Mears Ashby Issues and requests. Mar 2026

As this project is about to enter the Examiners review stage, we would like to submit further recommendations, without prejudice, in the event that the examiners approve the DCO. We believe these recommendations would make it more acceptable to the local community.

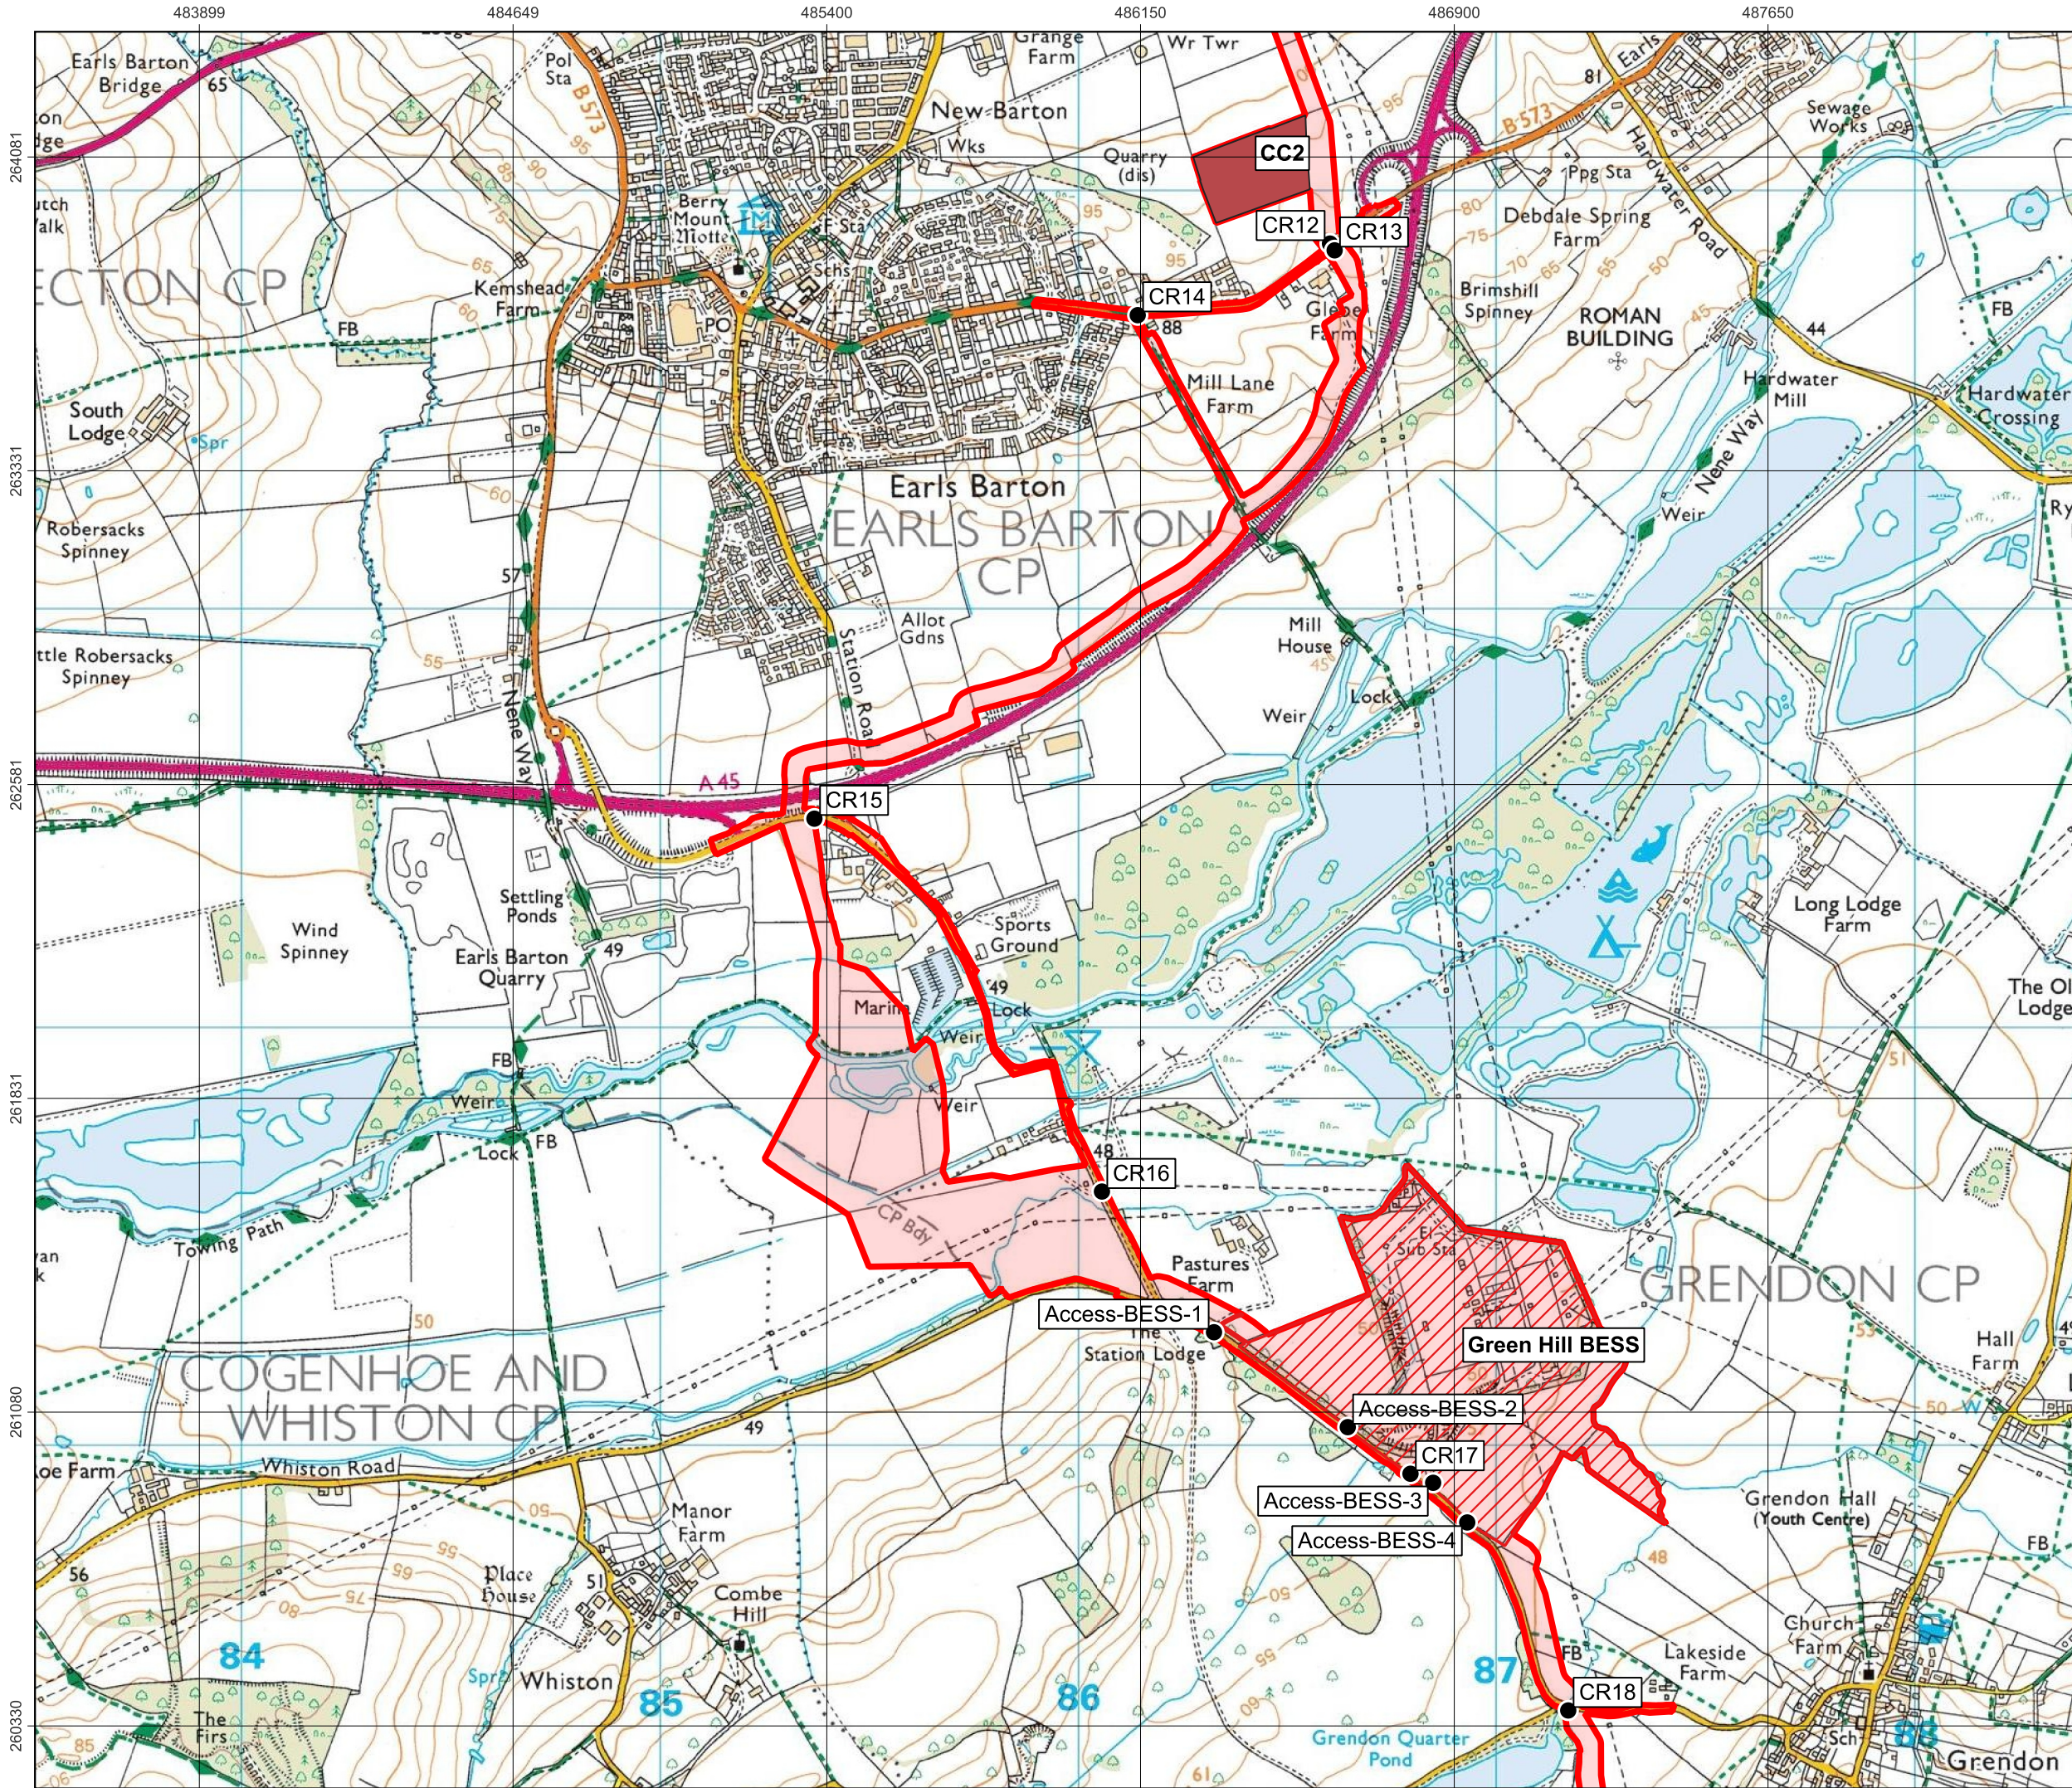
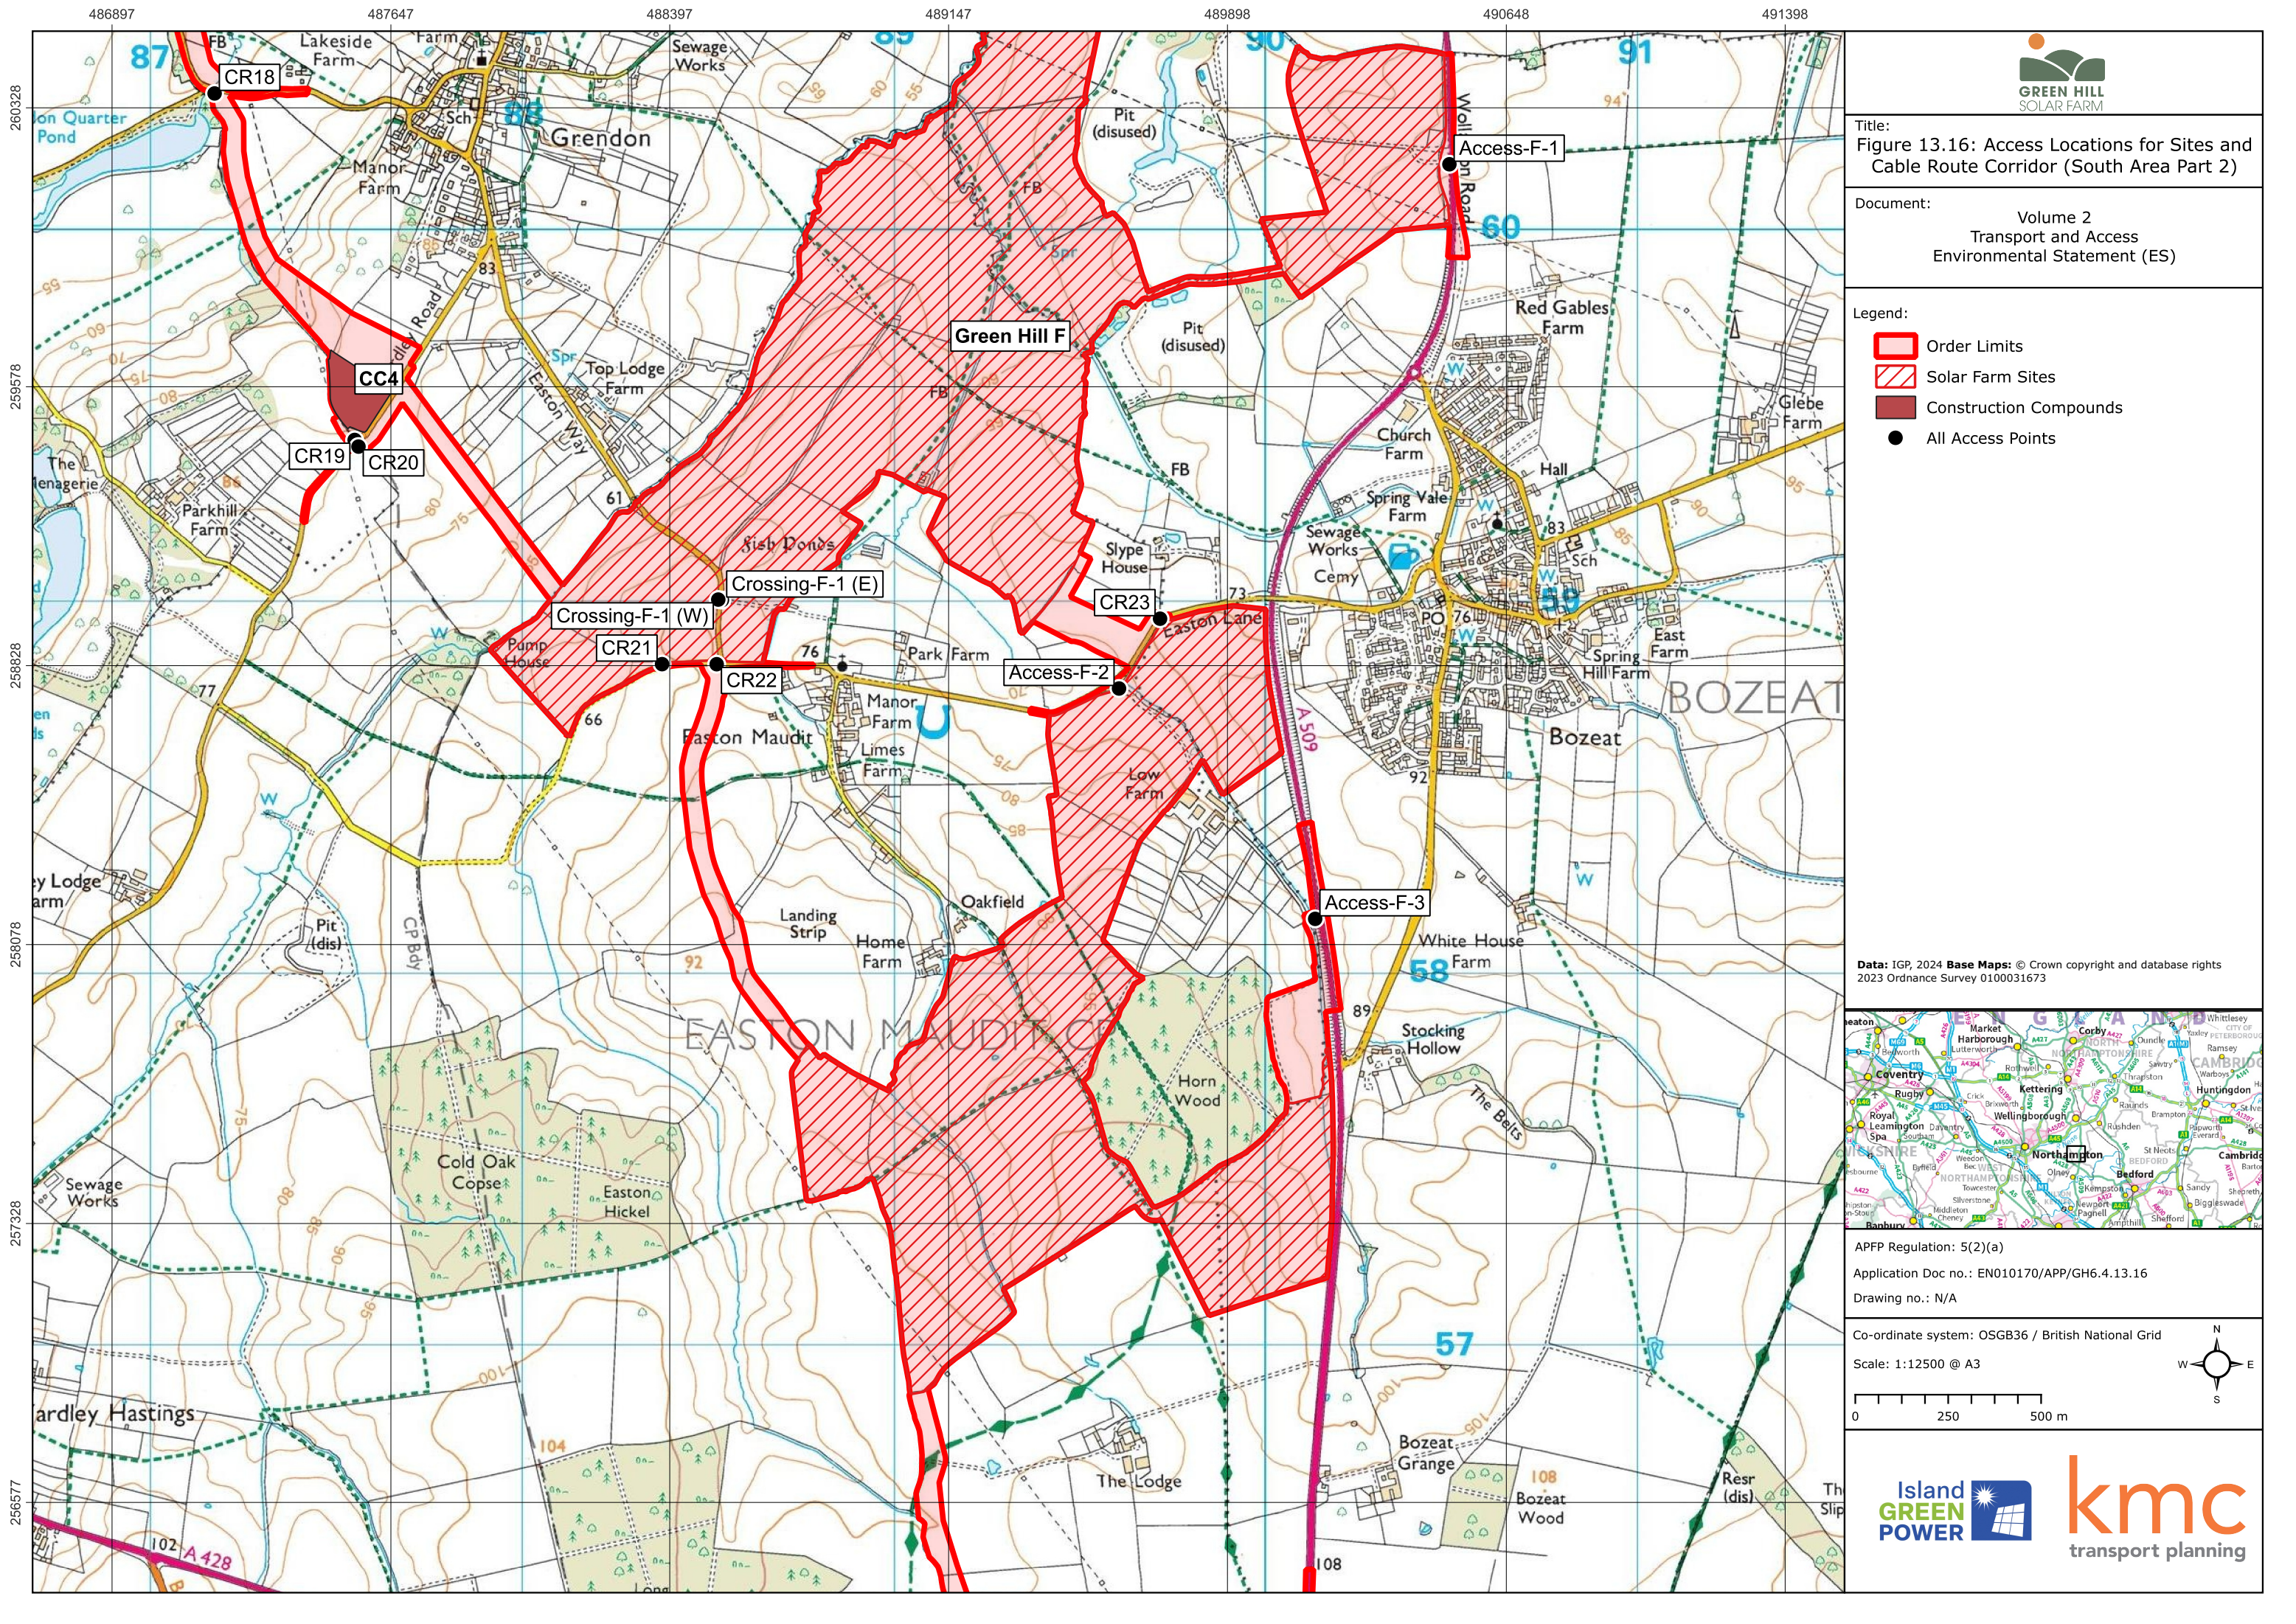
Highfield Road. Please can you review the 5 access points (which includes the cross-over for the cable route) on this road into sites D & E It is a short narrow country road, only 7m wide. The verges and road edges will not survive the number of HGV's you propose to service these areas. This is also a very busy commuter route and 4 sets of traffic lights will cause absolute chaos for commuters and school traffic.
